Tahmoor South Coal Project (SSD 8445)
Comments on the Environmental Impact Statement

EPA Comments on the Noise Impact Assessment for the Tahmoor Coal South Project

EPA Comments on the Water Impact Assessment for the Tahmoor Coal South Project

## Noise modelling - source locations

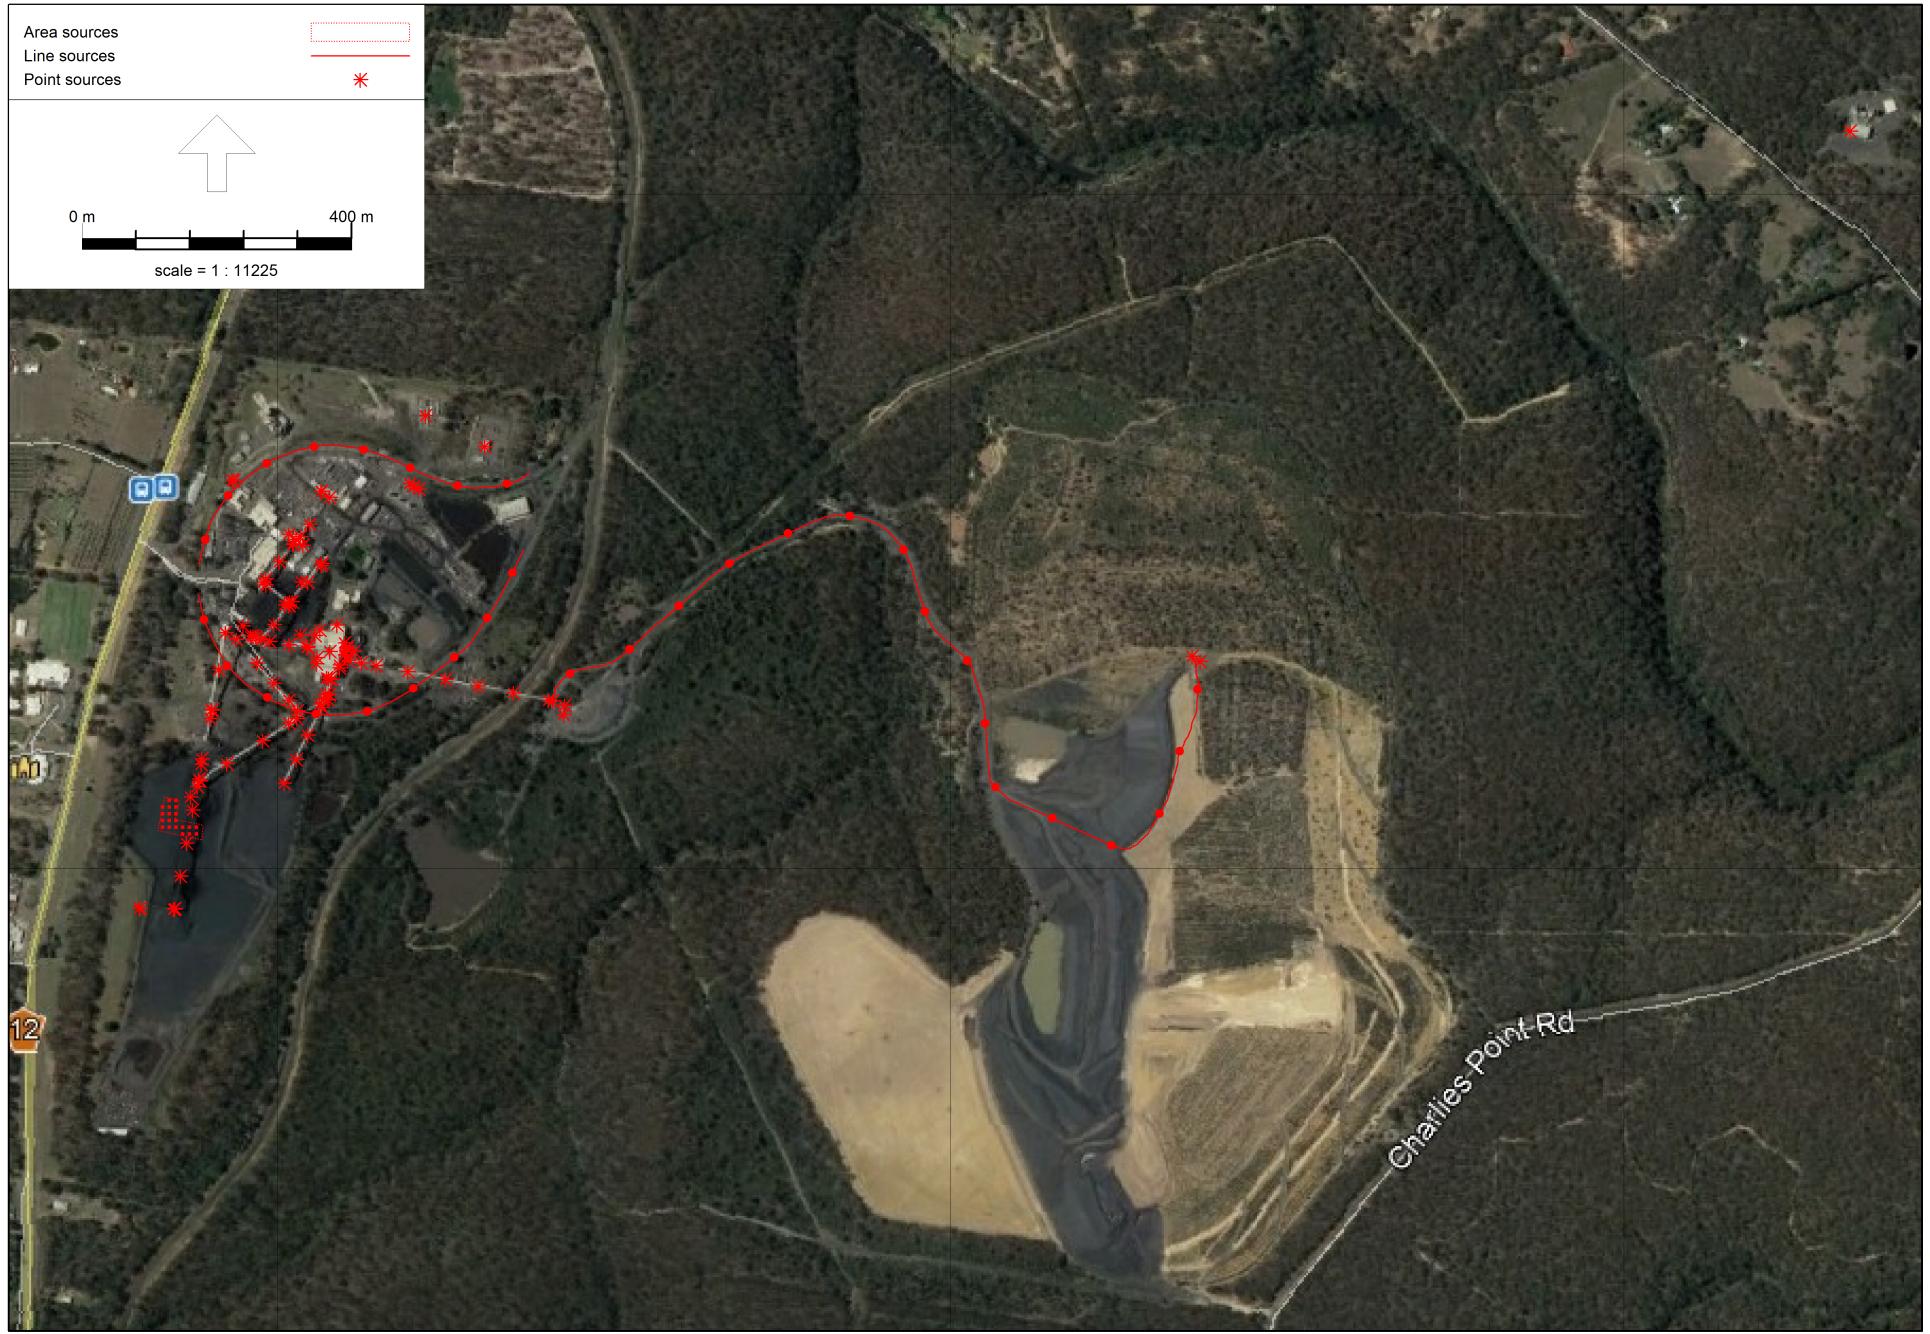
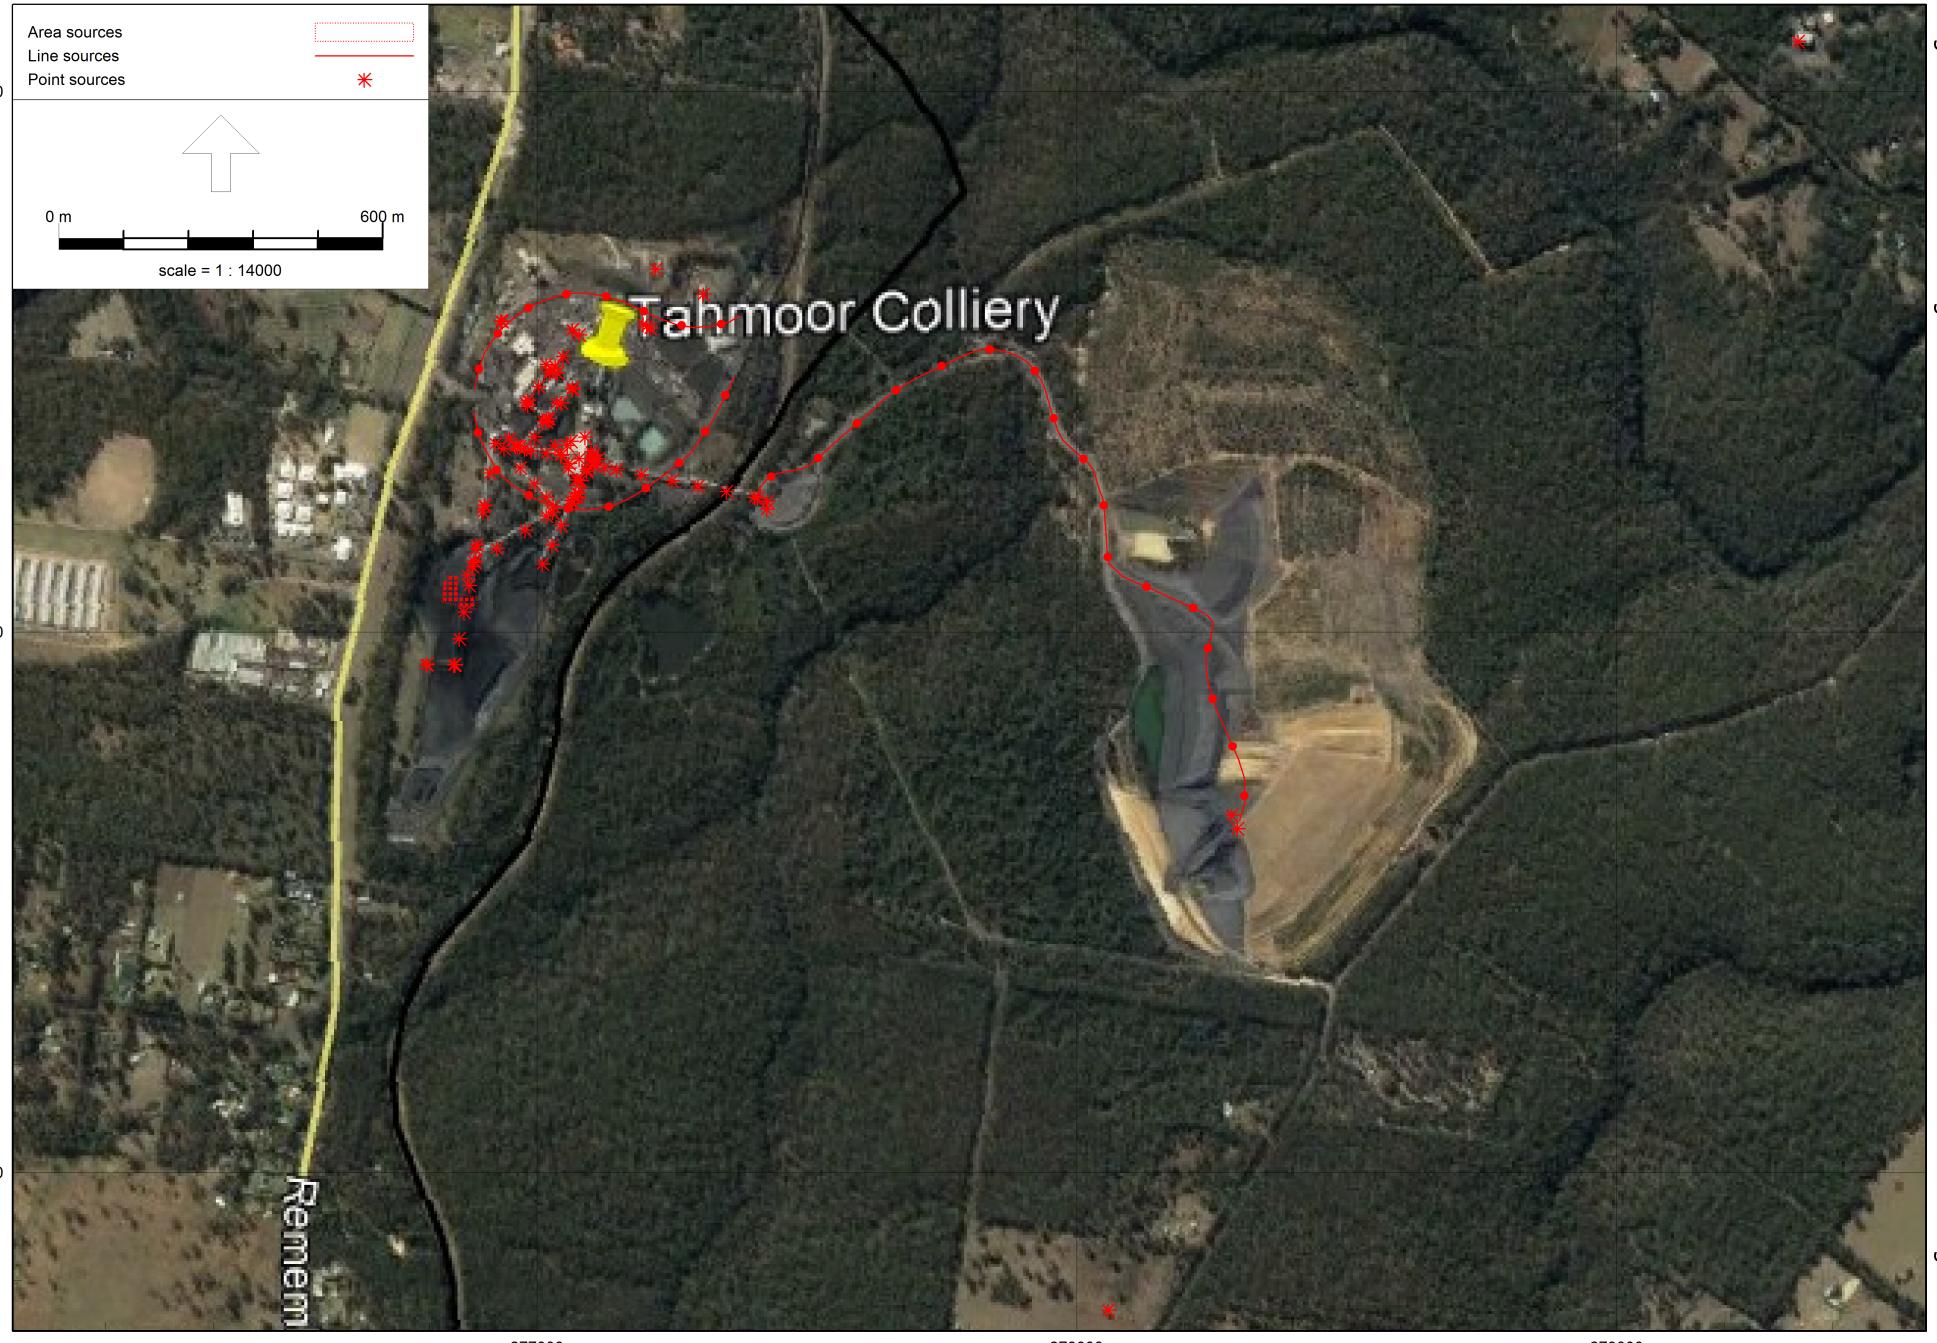
- 7) Appendix B noise source modelling maps should be accurately labelled to identify equipment and the dozers and on-site haul trucks moving on and between the stockpiles (product and ROM). This should be included in the revised model to derive a worst-case scenario at receivers.

- 19) The proposed mitigation scenario is contingent on ceasing REA operations during the night. A residual impact analysis should be provided for other time periods. In addition, the proponent needs to clarify why the source location map in Appendix B for the mitigated scenario (Figure B.3) includes sources in the REA, which is intended to be operated during daytime period only. Figure B.3 should also illustrate the proposed extent of the TSP REA.

- 20) The barrier mitigation (increased height of the northern bund and a proposed barrier adjacent to the stockpiles) described in Table 7.2 should indicate the assumed attenuation provided by the barriers. In addition, the proponent should review and, if appropriate, amend the source location maps (Appendix B), which indicate the northern bund running parallel to the rail line. Satellite maps of the surface infrastructure (Figure 3.3 in the EIS) indicate that the bund runs behind the water recycling plant and vent shaft 3, not parallel to the rail line, which will impact the effectiveness of the assumed barrier attenuation.
